## 48-154 HIGH STREET, UXBRIDGE RESPONSE TO LONDON FIRE BRIGADE COMMENTS

HL9152/BY/Issue 1  
09/01/2025

We are writing to acknowledge the comments provided by the London Fire Brigade regarding the Fire statement for 148-154 HIGH STREET UXBRIDGE UB8 1JY.

Drawing Title
Basement Plan

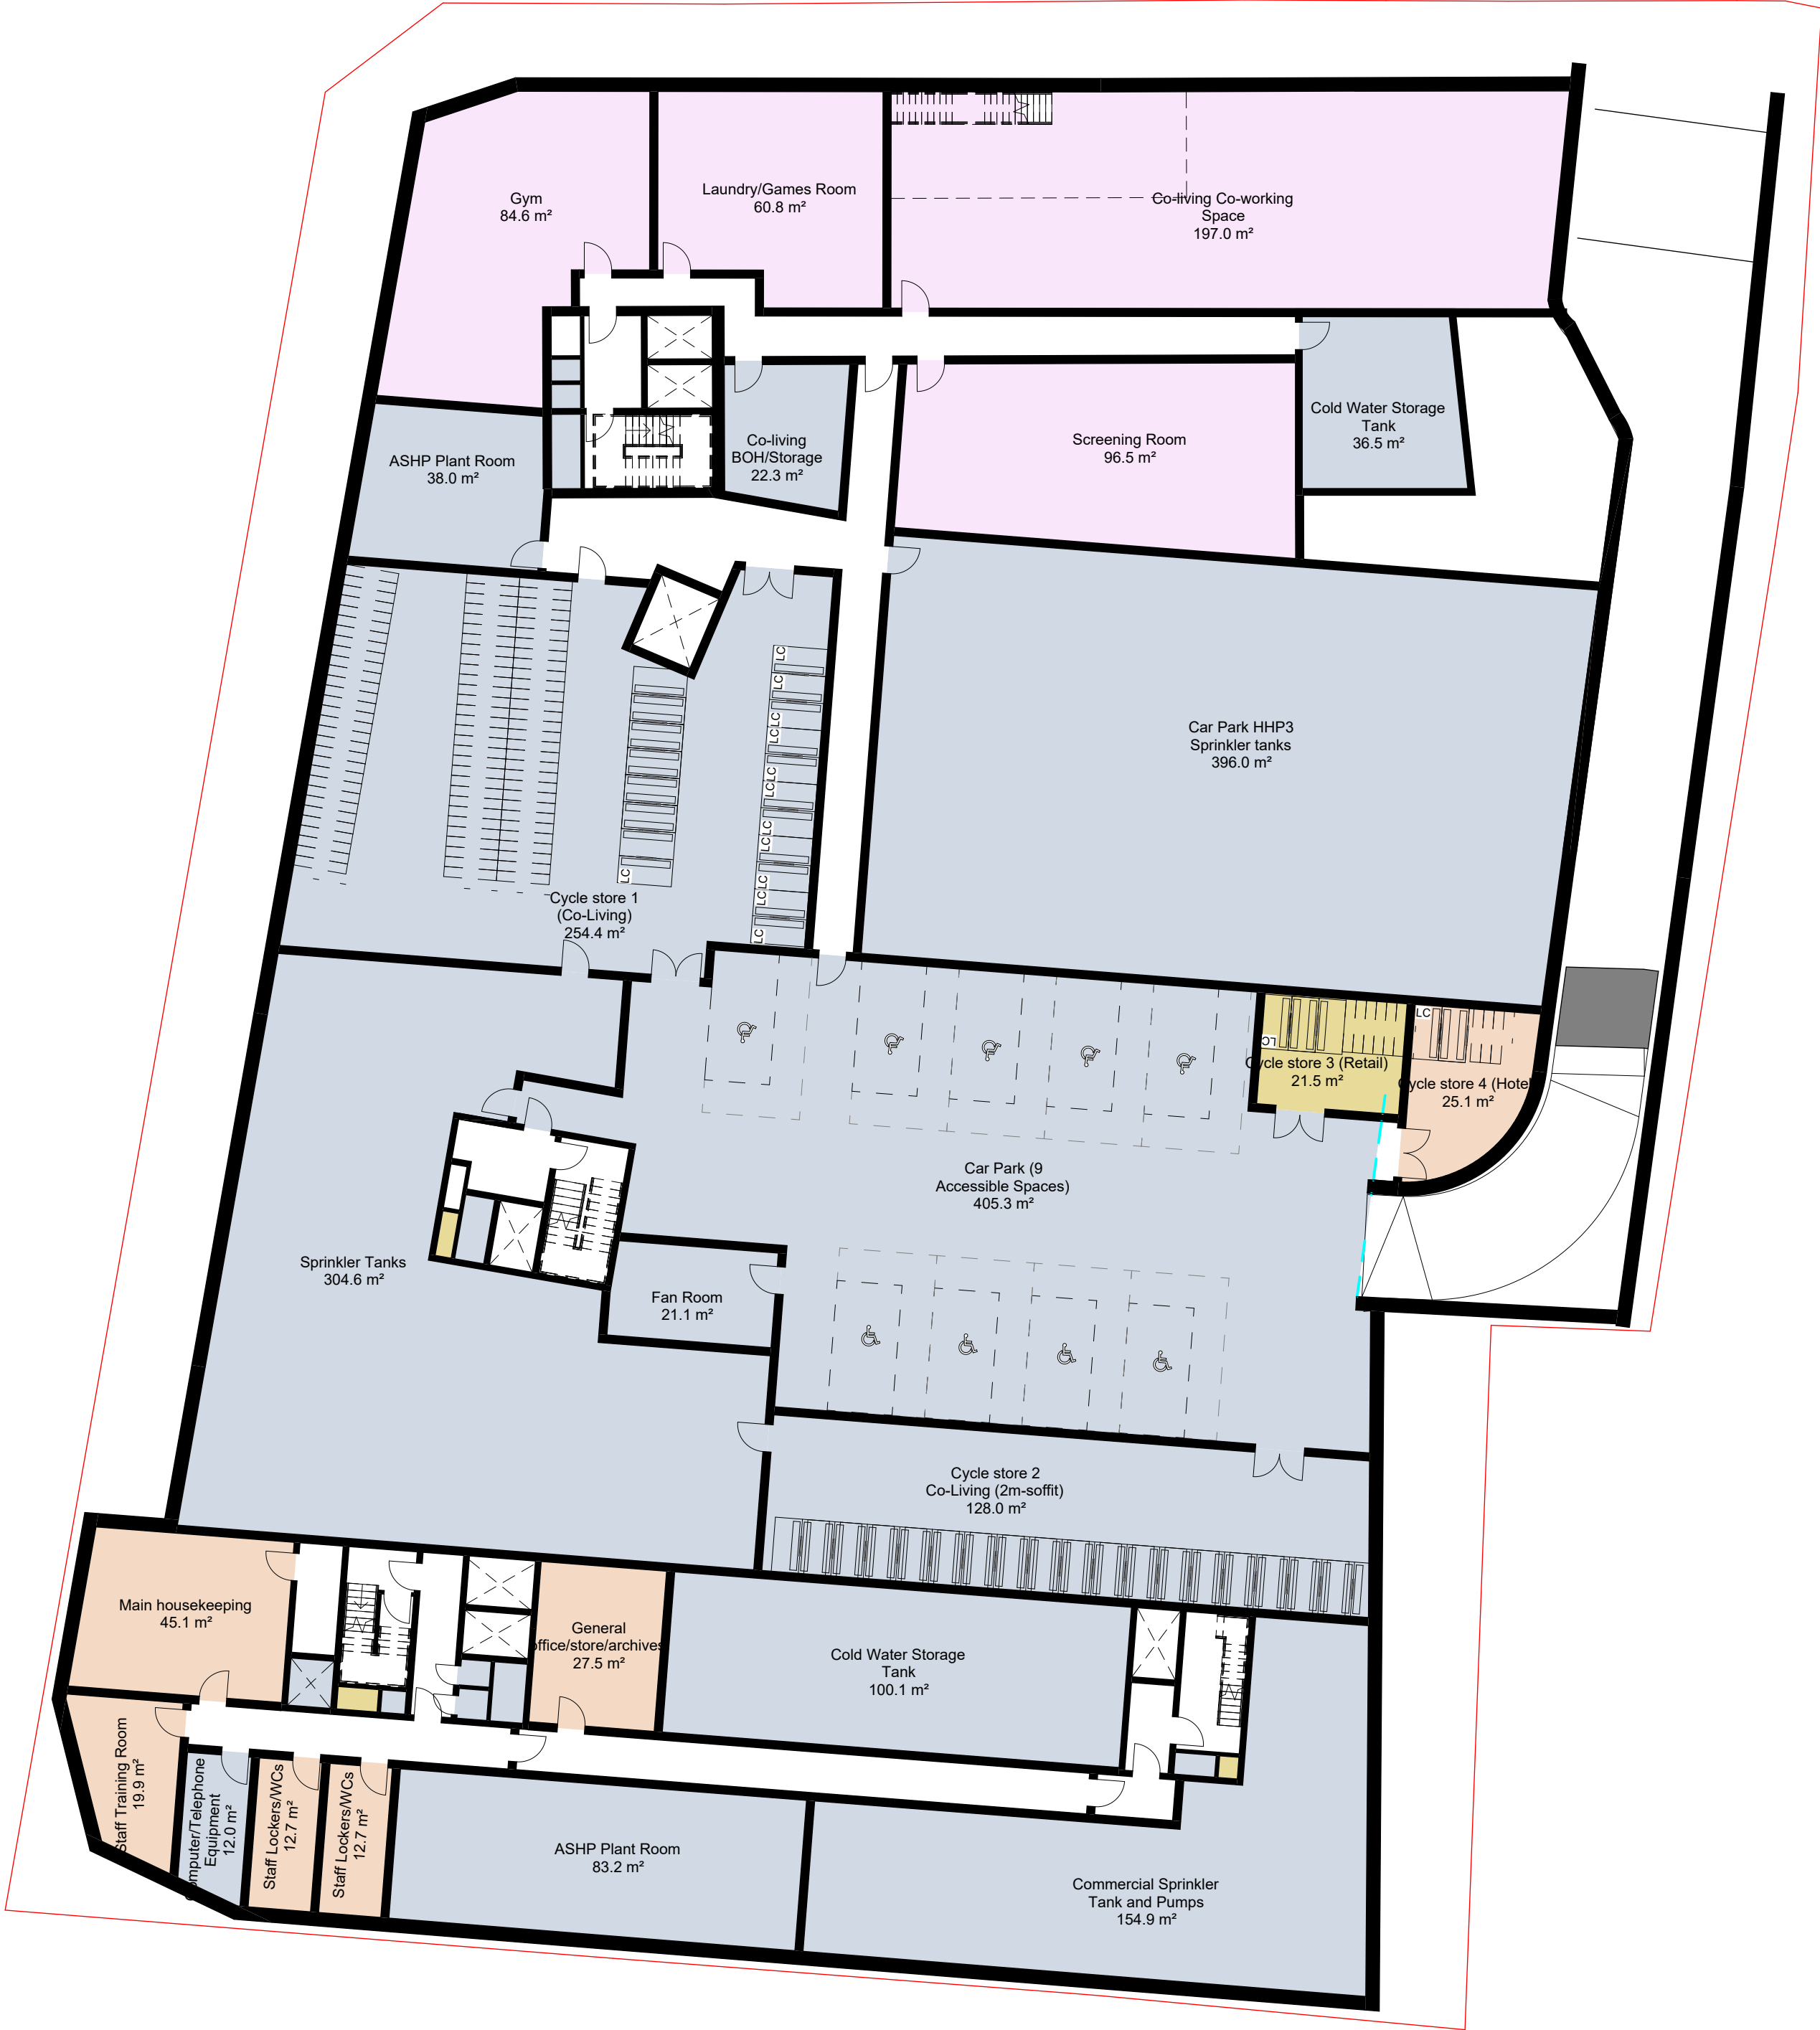
7. The bin store will be separated from the final exit of one of the firefighting stairs by a smoke-vented lobby. The remaining stairs will not have any ground-floor connections for access, except through the lift lobby.
